Address: 8 Basket Lane
(Lot 18 Riverwalk submission)

C-B-L: 390-A-018
permit # 2015-01818

CHECK-LIST AGAINST ZONING ORDINANCE

Proposed Use/Work - new two story - 26' x 28' single family w/ attached 18' x 24' garage

DRAWINGS THIS SHEET
ELEVATIONS

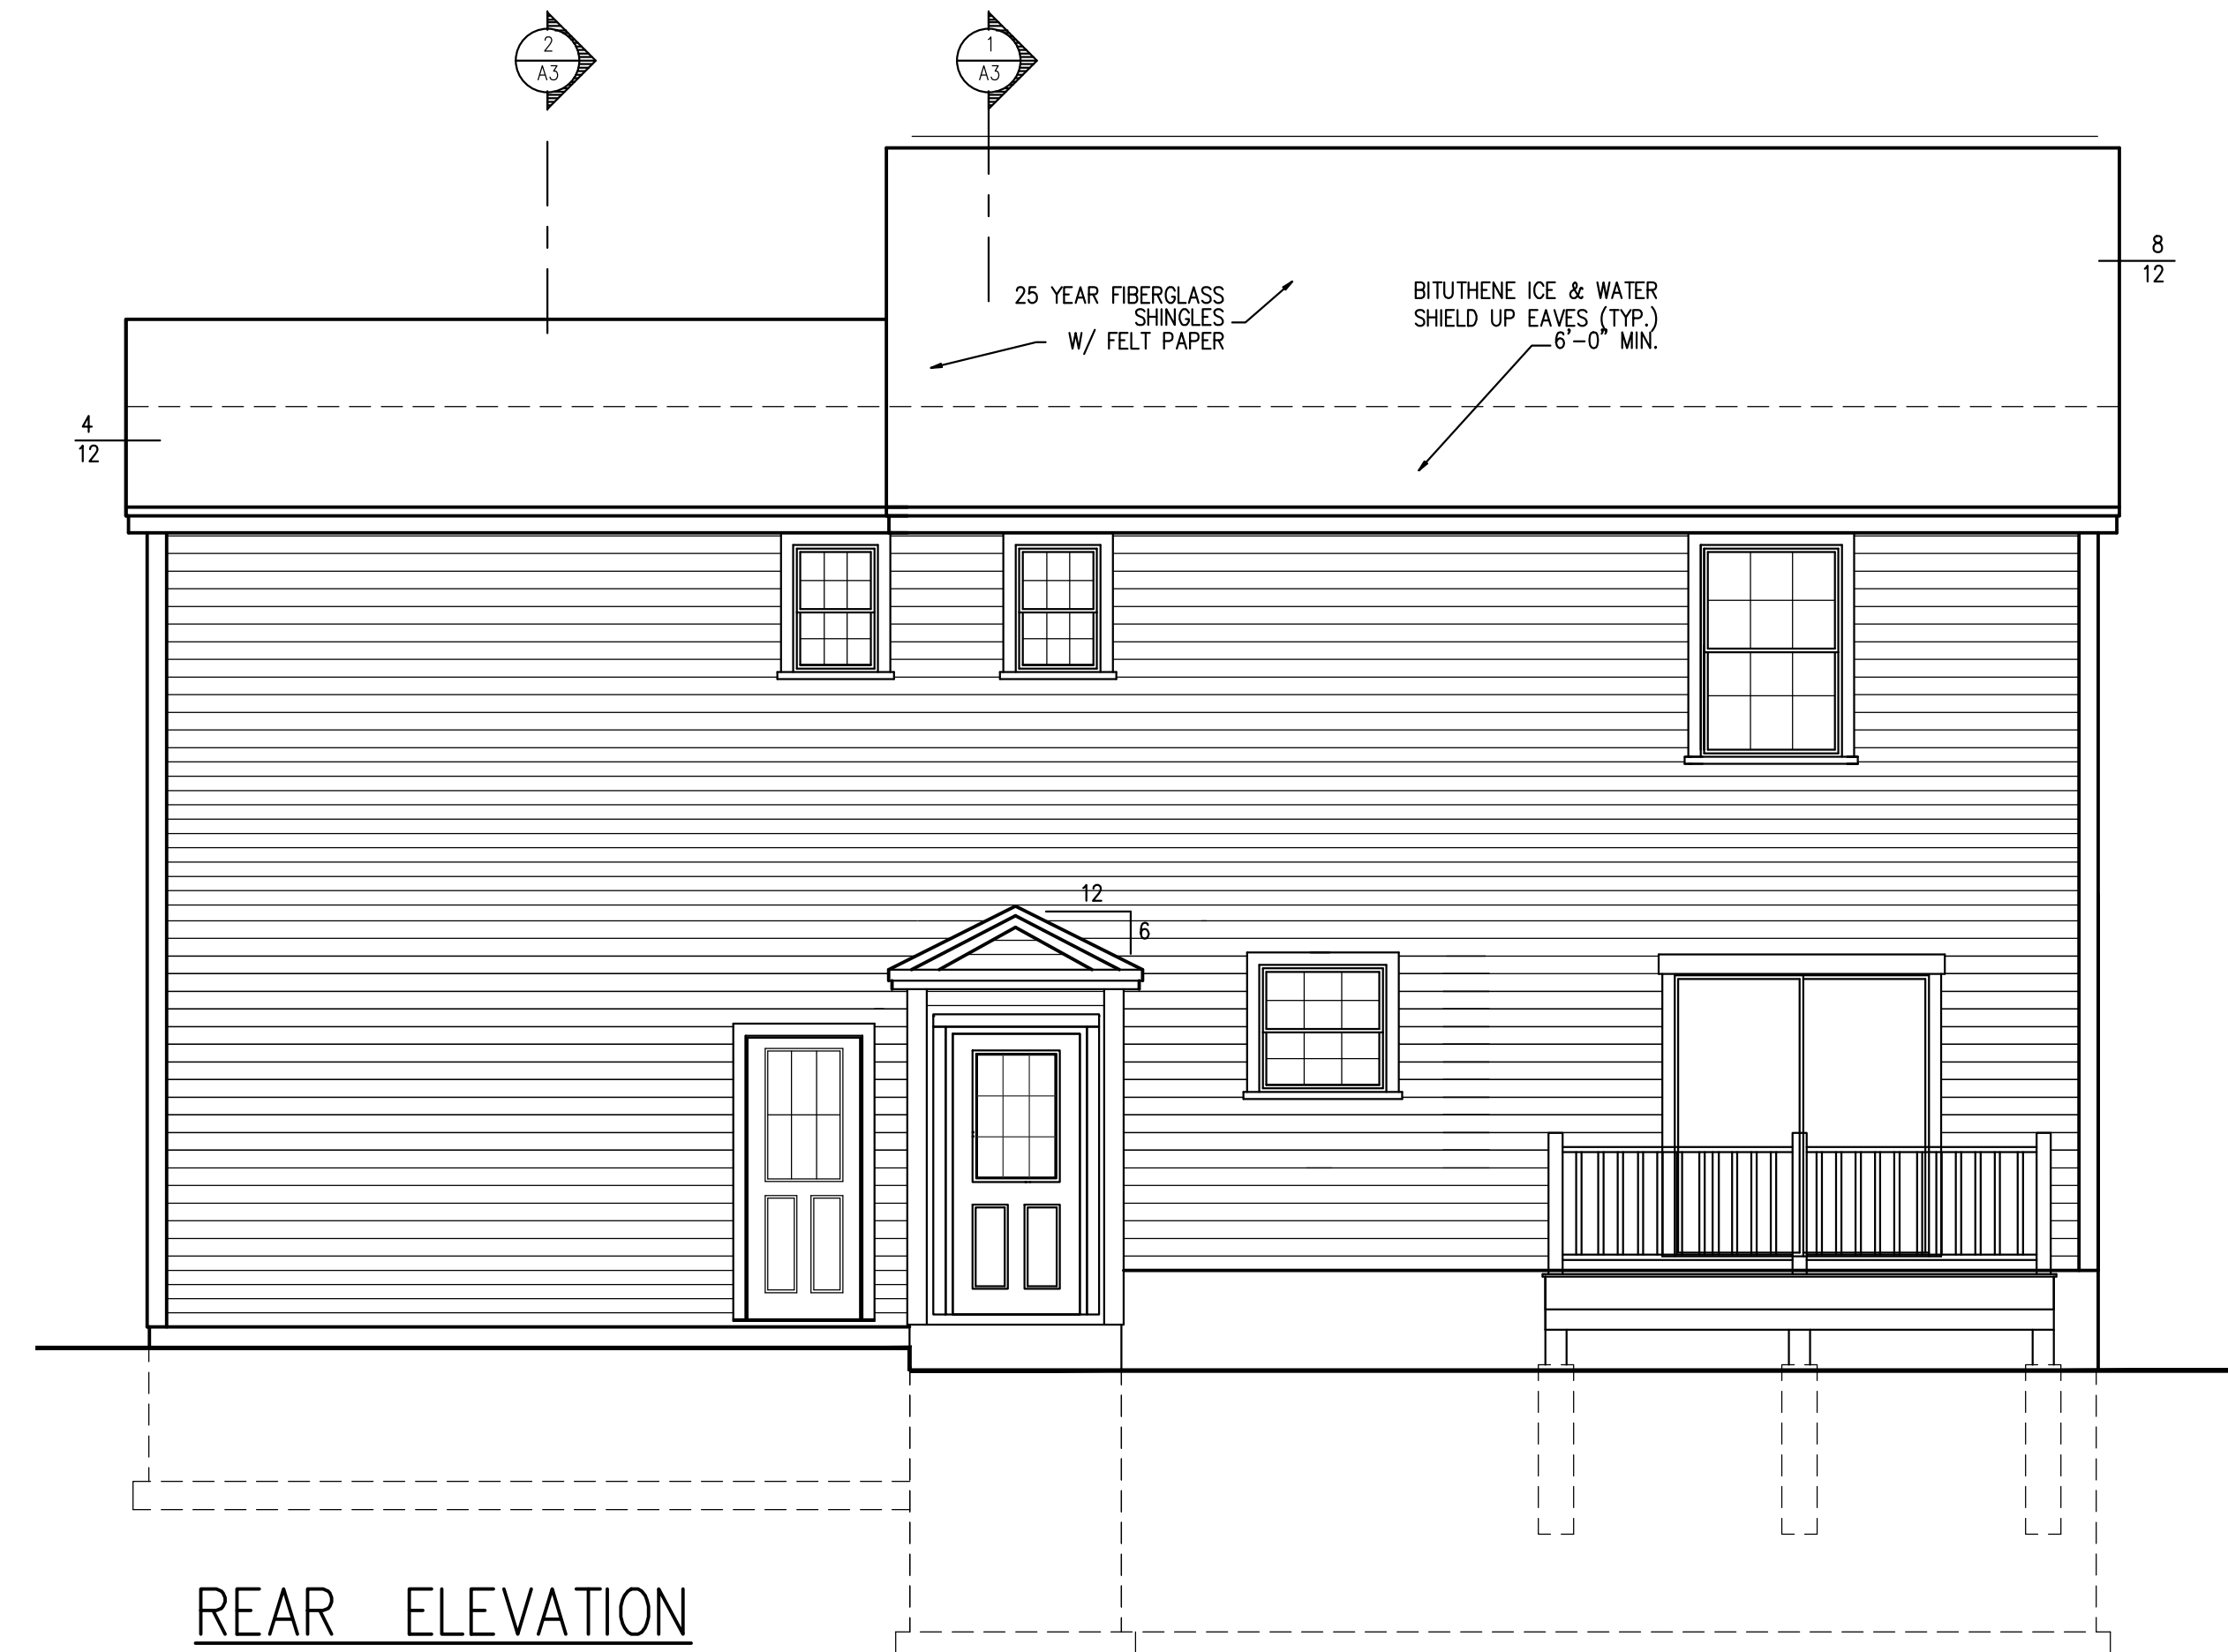
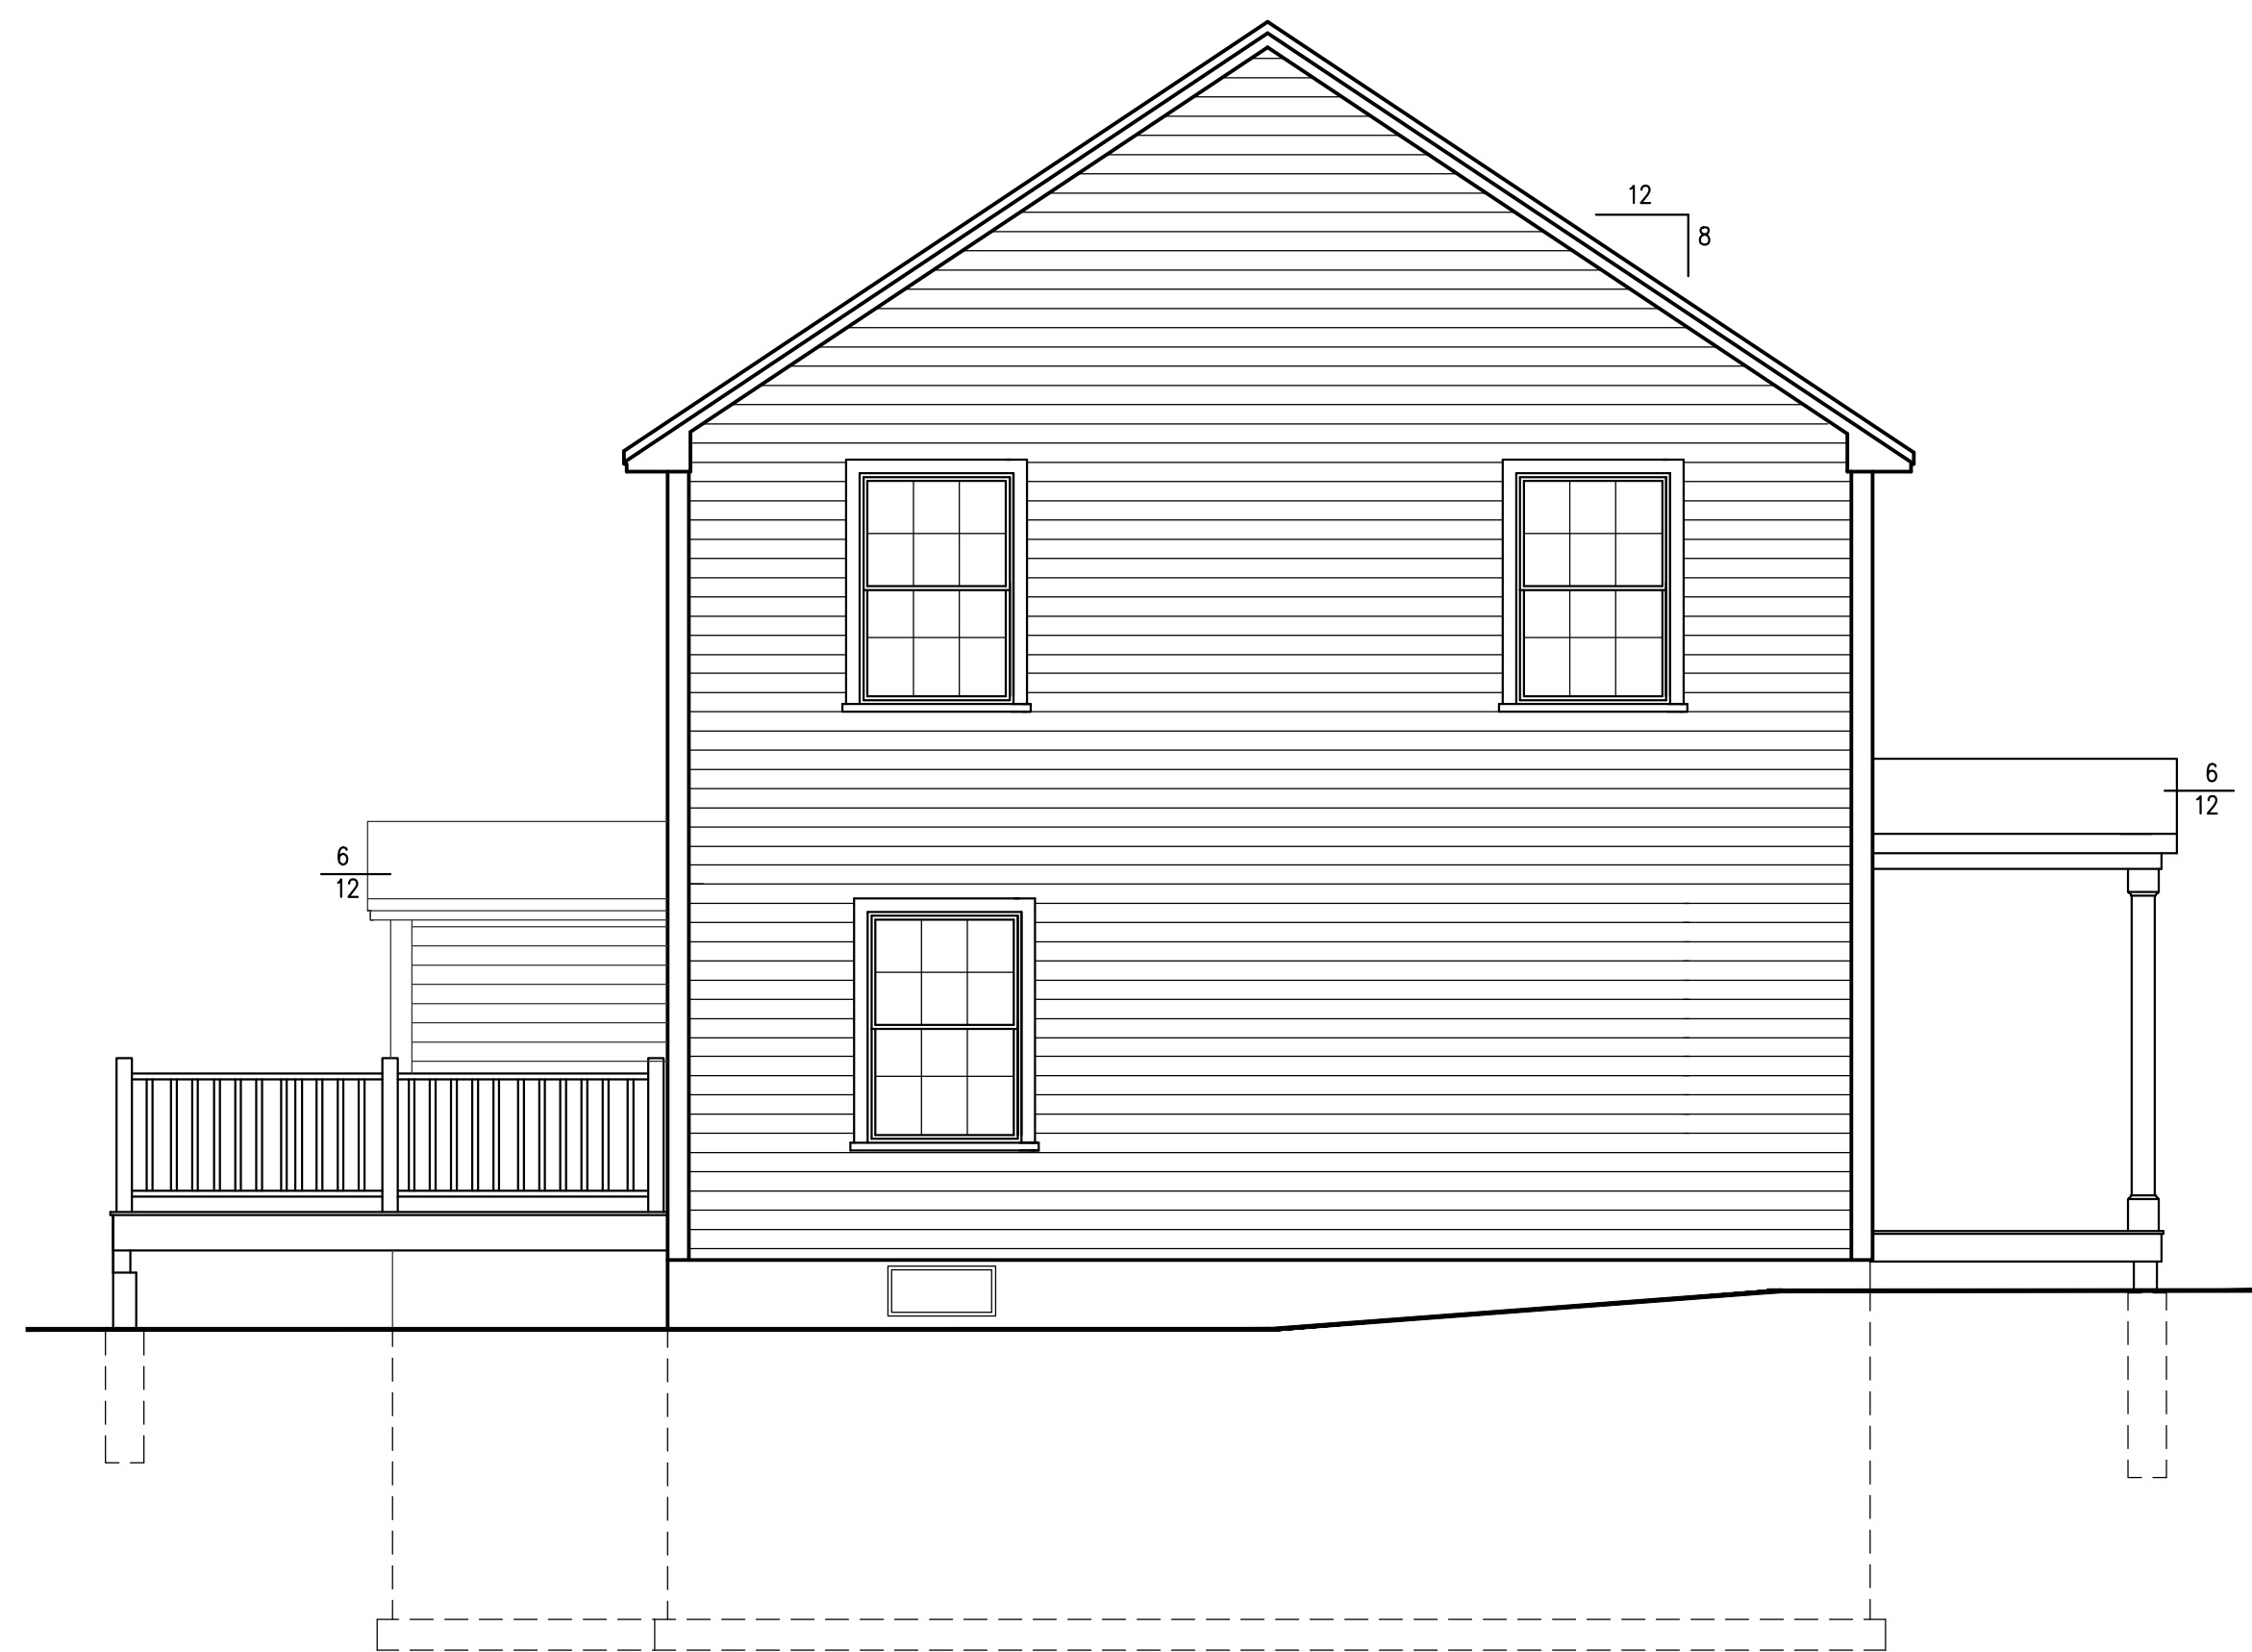
Height - 35' max - 28' setback to ridge (OK)
